HONOR CHARTER SCHOOL

HONOR CHARTER SCHOOL BUILDING CORPORATION
8250 Bent Grass Meadows Drive, Peyton, Colorado 80831
Owner Project No. 3225193
AGENCY NUMBER: AHCA-123456.78

V1_Lighting Plan.pdf Markup Summary

ELECTRICAL
SITE PLAN

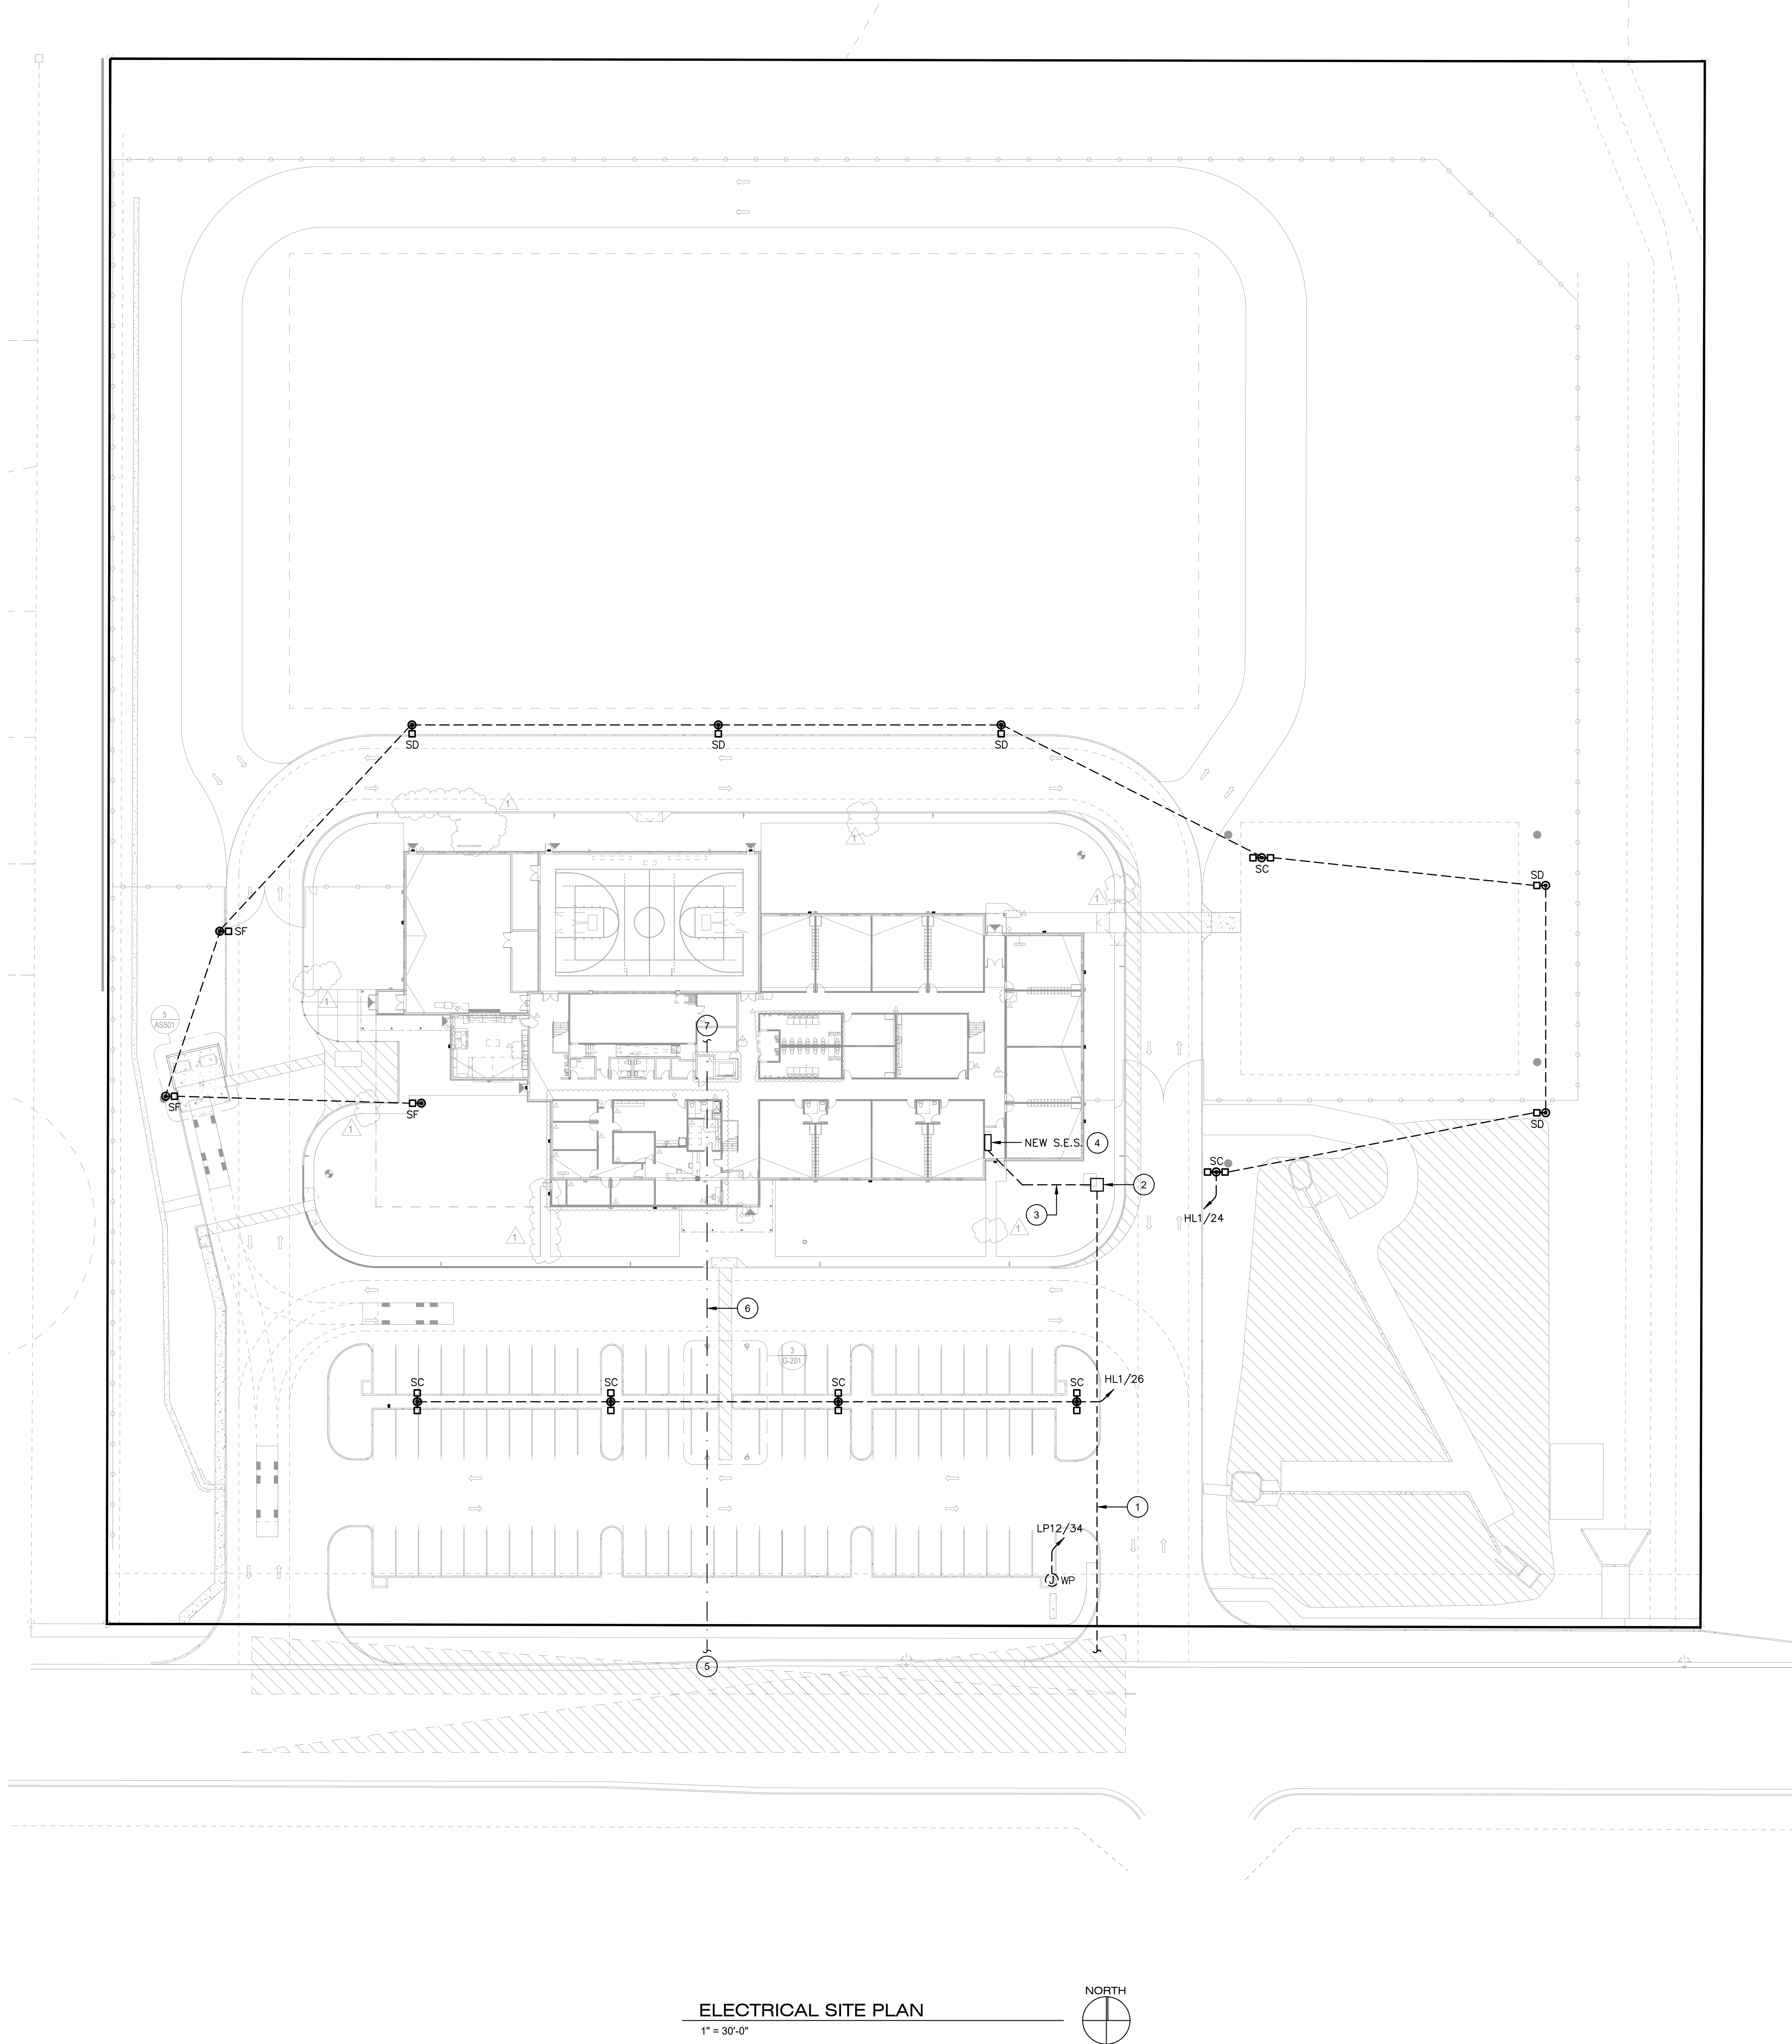
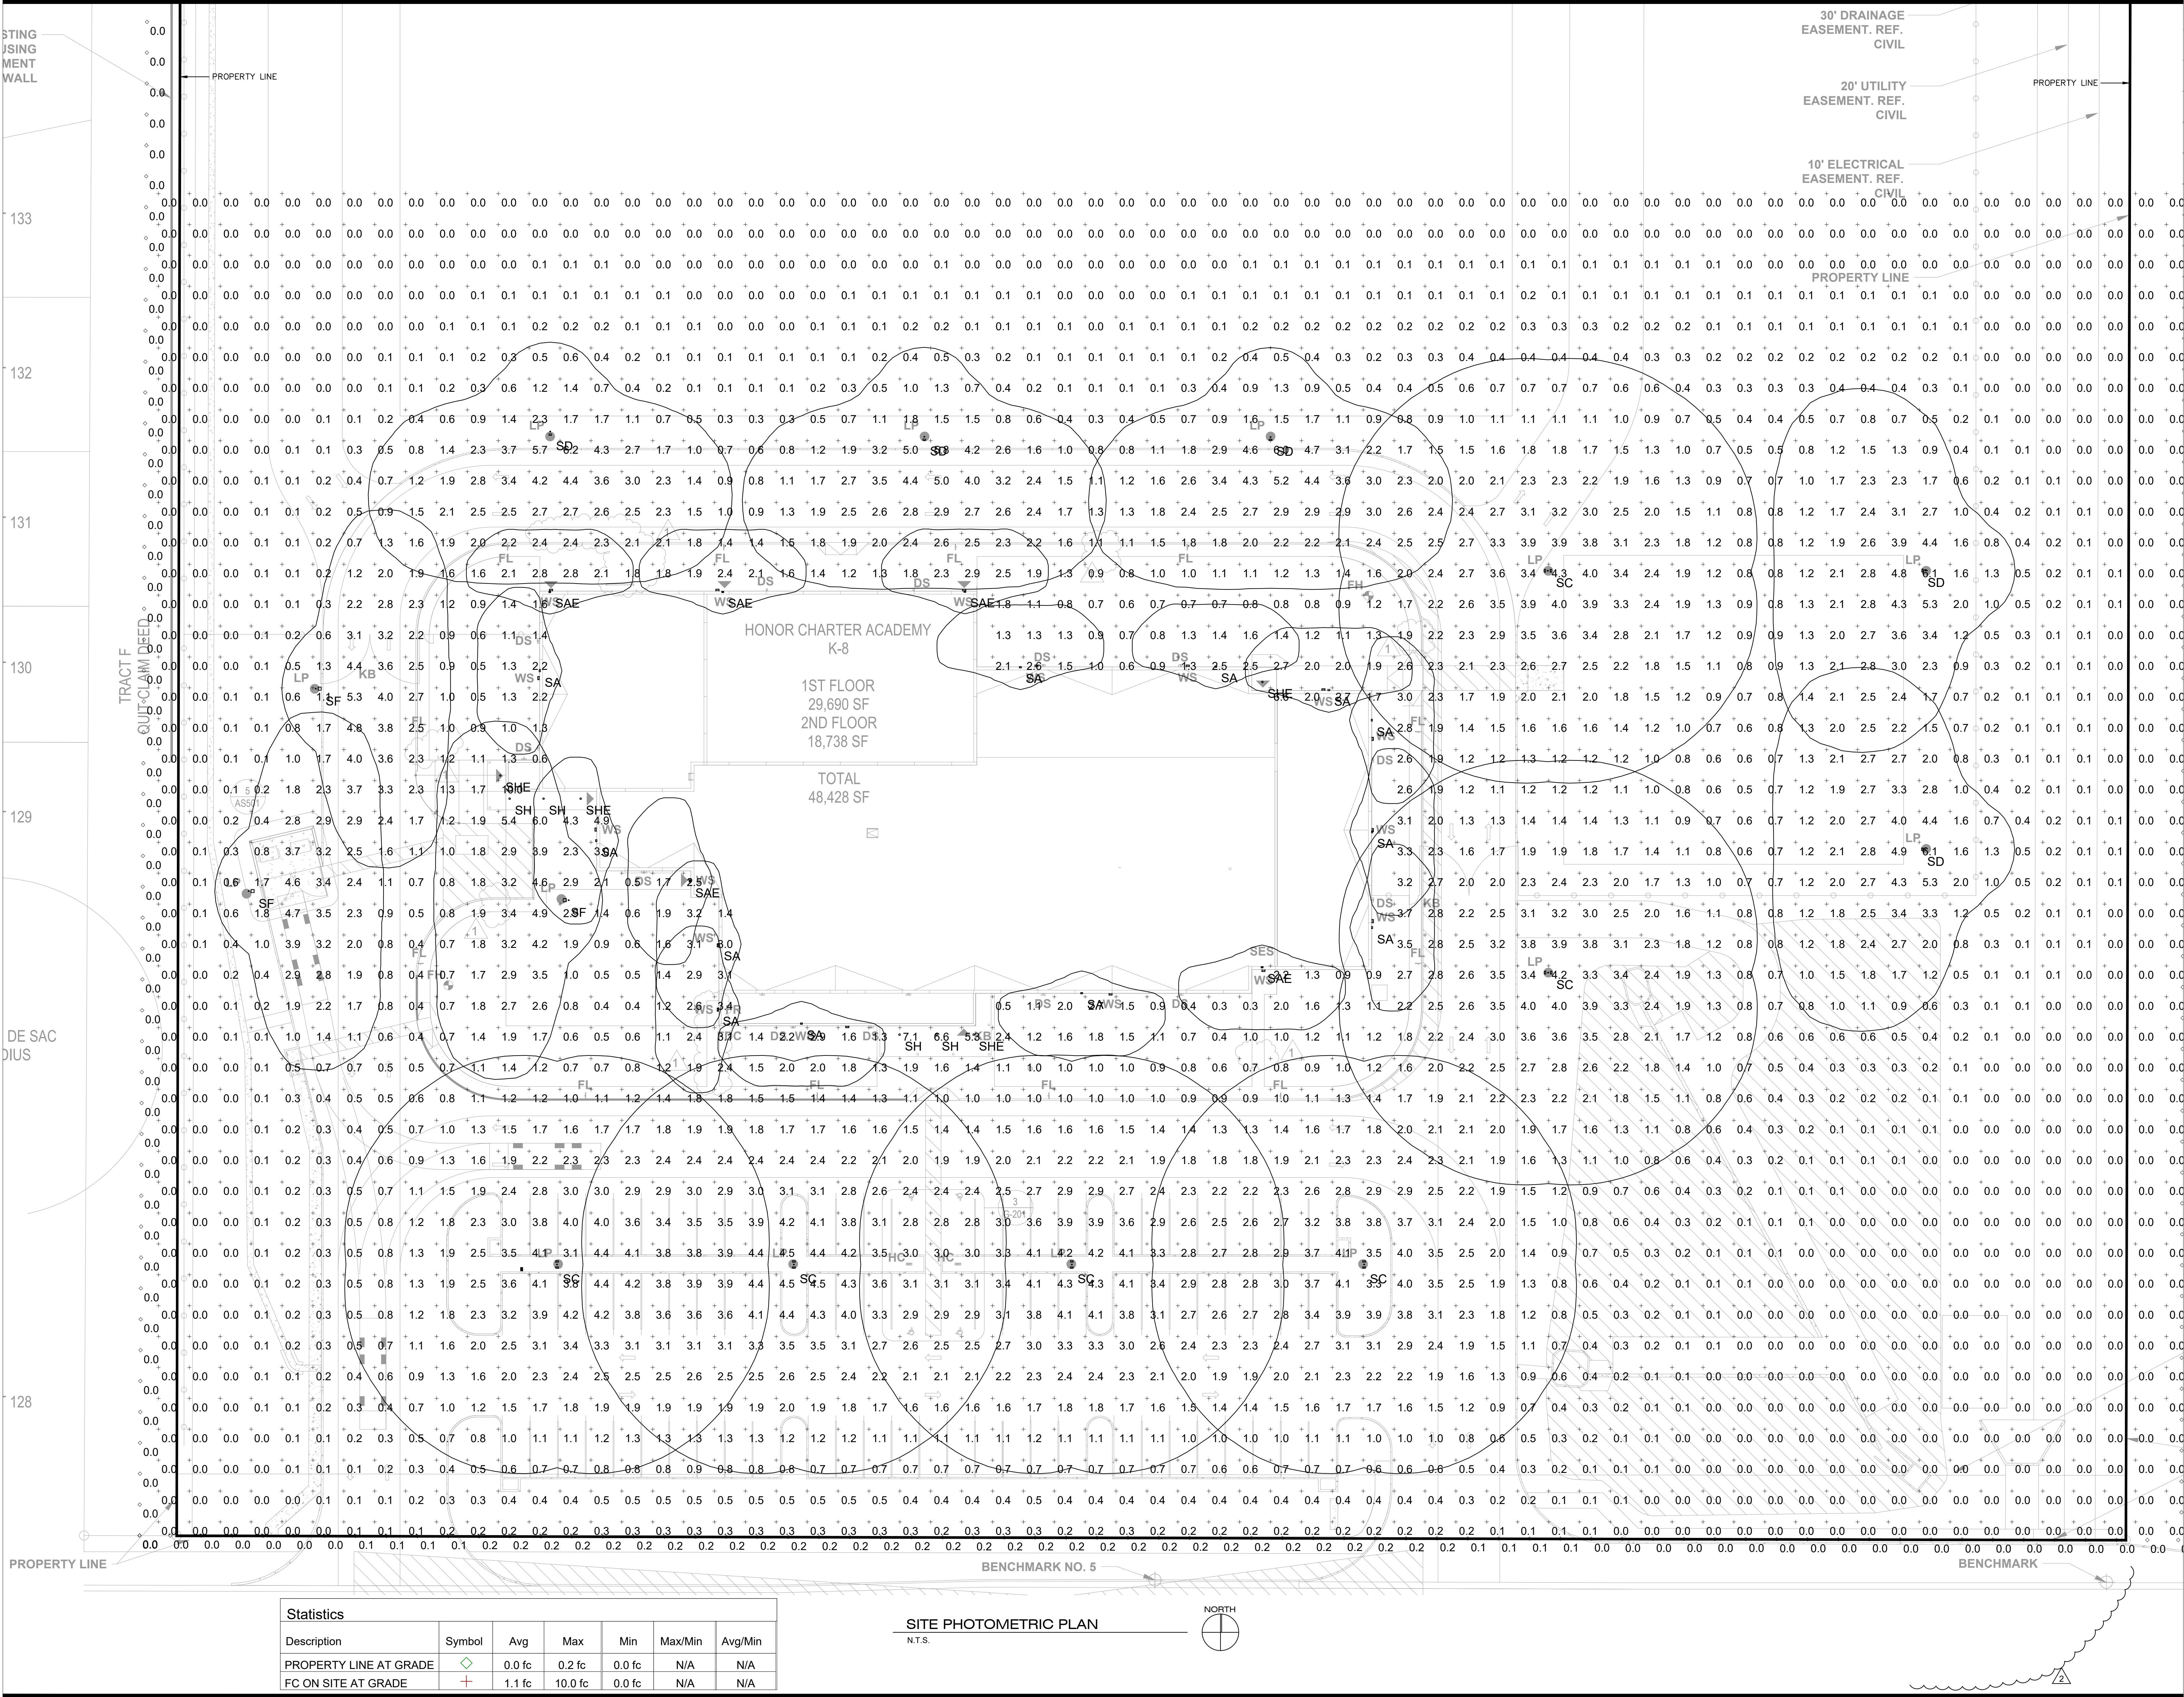
identify hours, height,
cut off etc see Land
Development Code,
section 6.2.3

identify hours, height, cut off etc see Land
Development Code, section 6.2.3

SHUT OFF SCHEDULE IS DESIGNED TO COMPLY WITH THE
ABOVE. SHUT OFF SCHEDULE "NOTE L" HAS BEEN ADDED
TO GENERAL NOTES/ REF SHEET ES-111.

ES-112

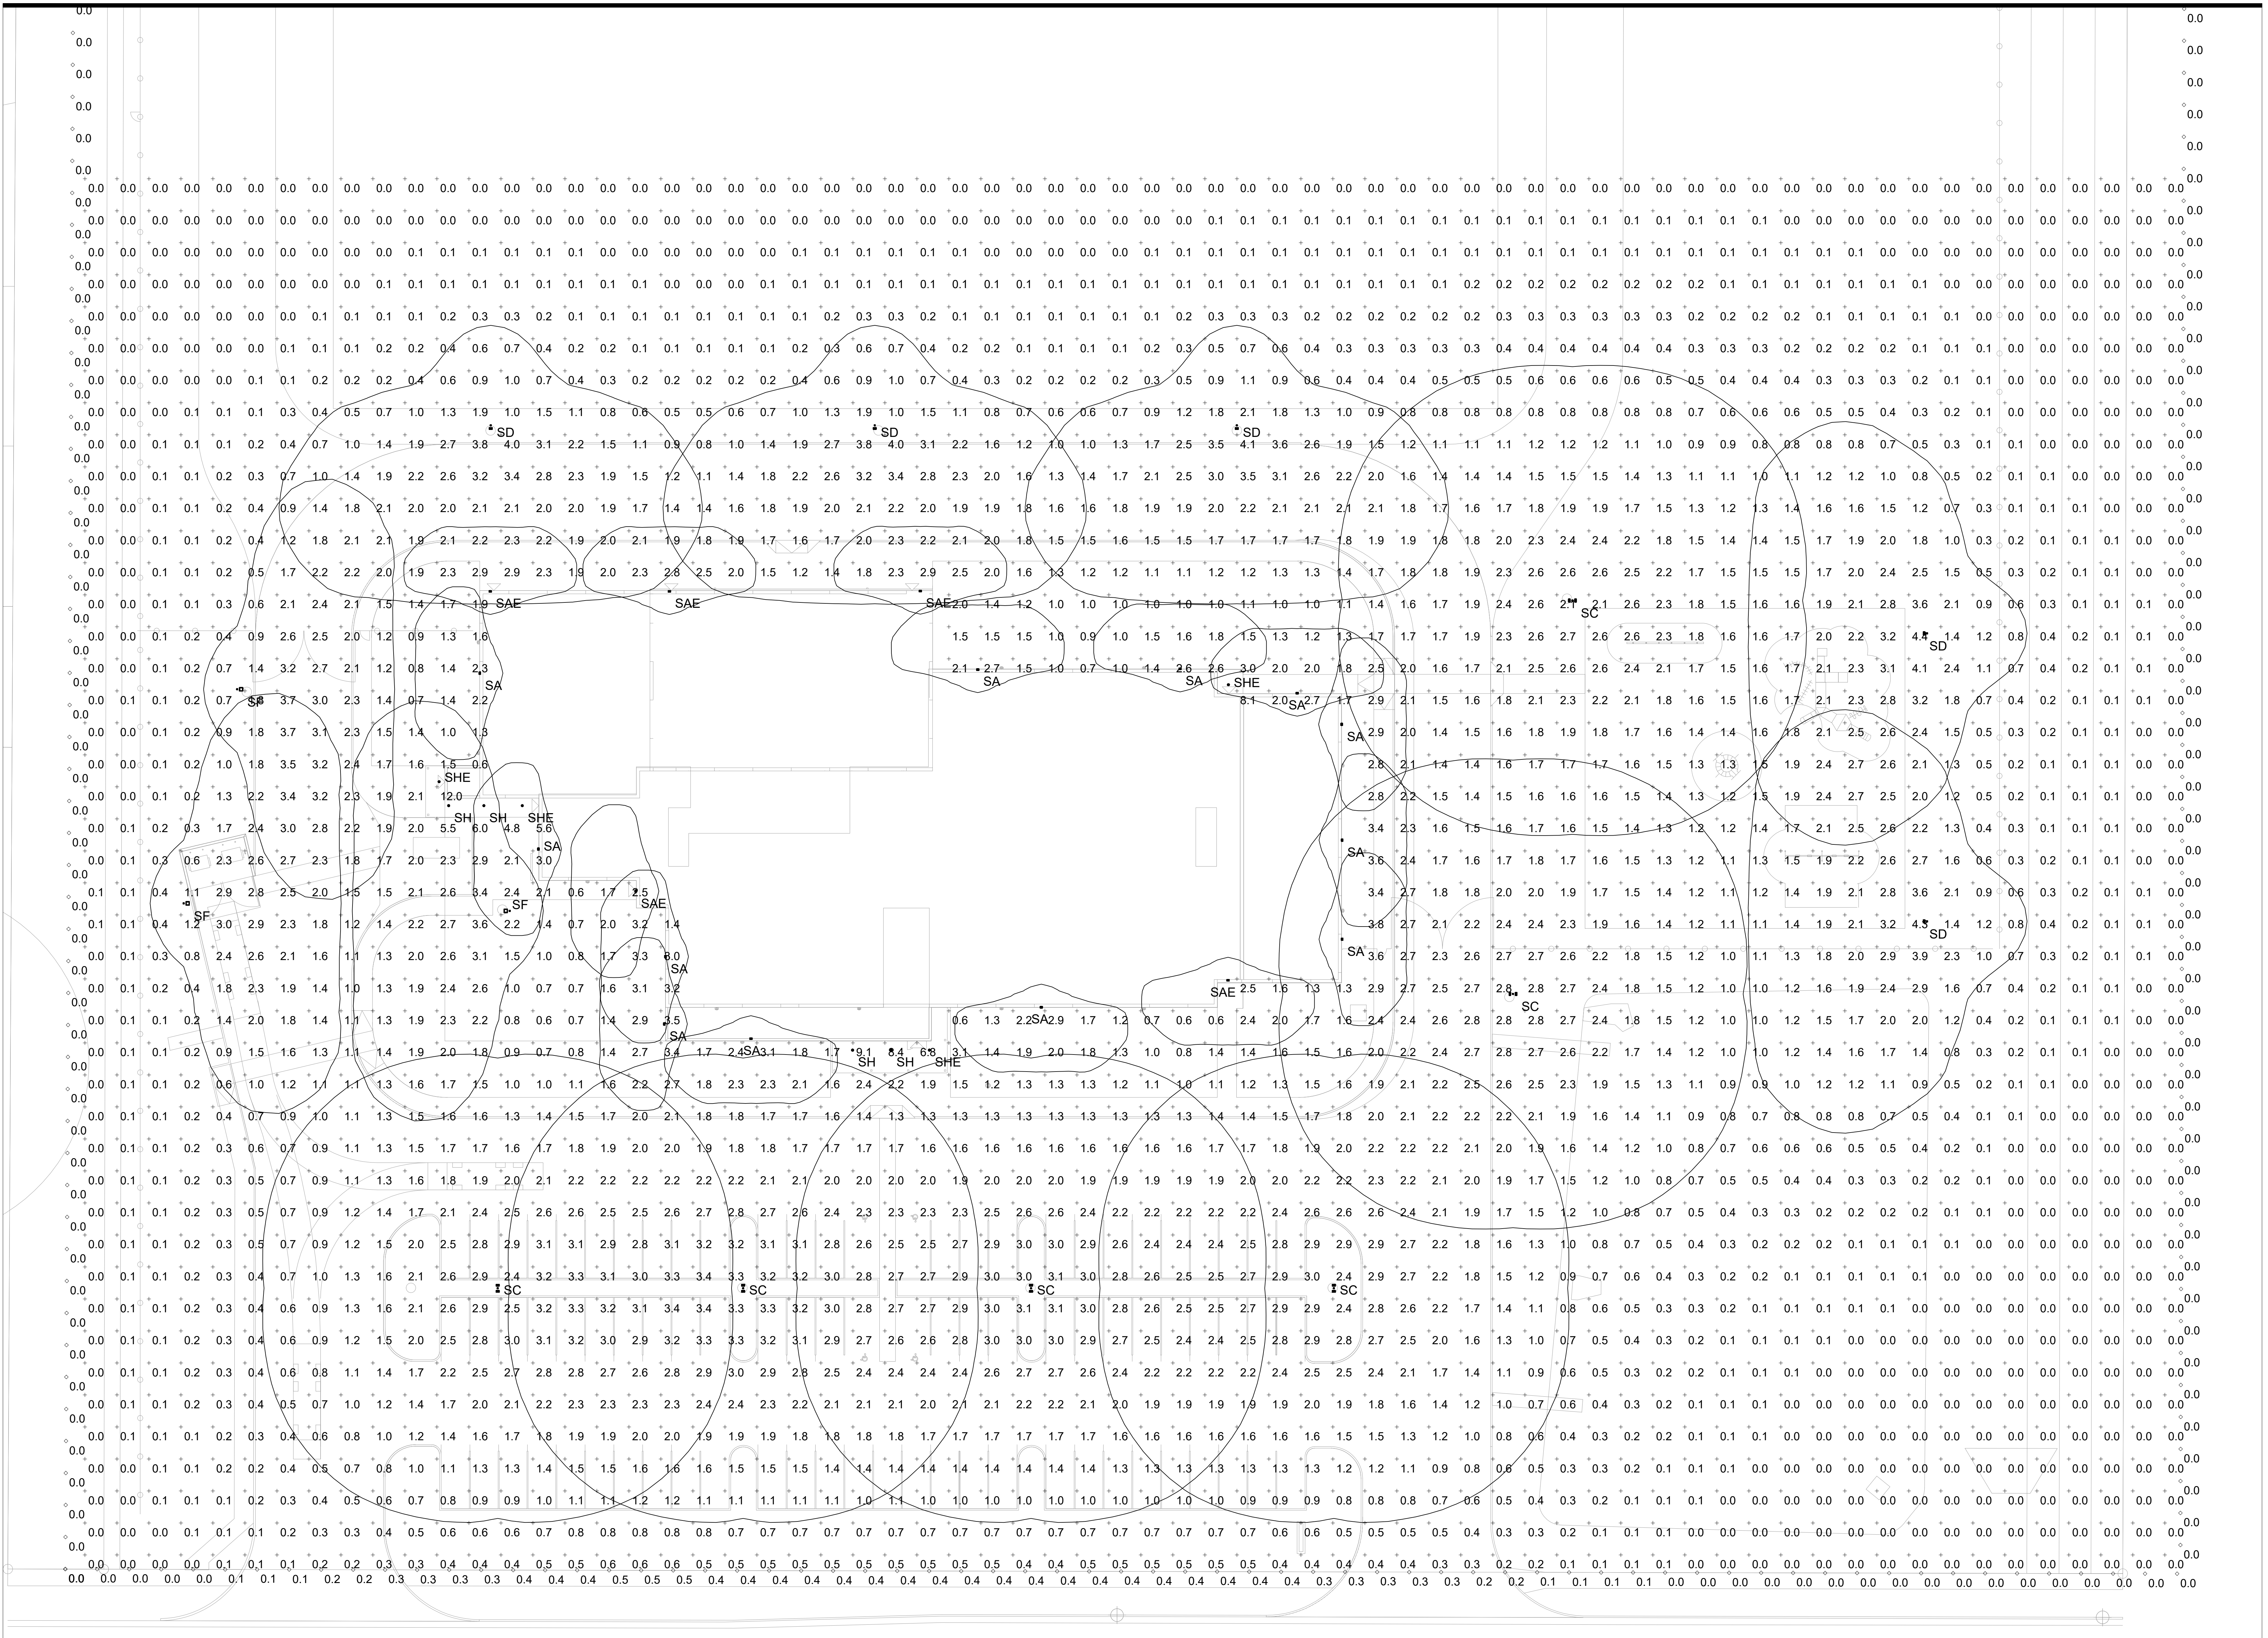
Add property lines and verify full cut off fixtures and provide height of pole mounts. Please see lighting standards in Code

is this sign electric and does it change messages?
provide lumens at property lines

PROPERTY LINES HAVE BEEN IDENTIFIED

1 & 2. DESIGN INTENT IS TO PROVIDE POWER FOR FUTURE SCHOOL SIGNAGE BY OTHERS/ SIGNAGE IS PROPOSED TO BE BACKLIT STATIC SCHOOL NAME AND LOGO
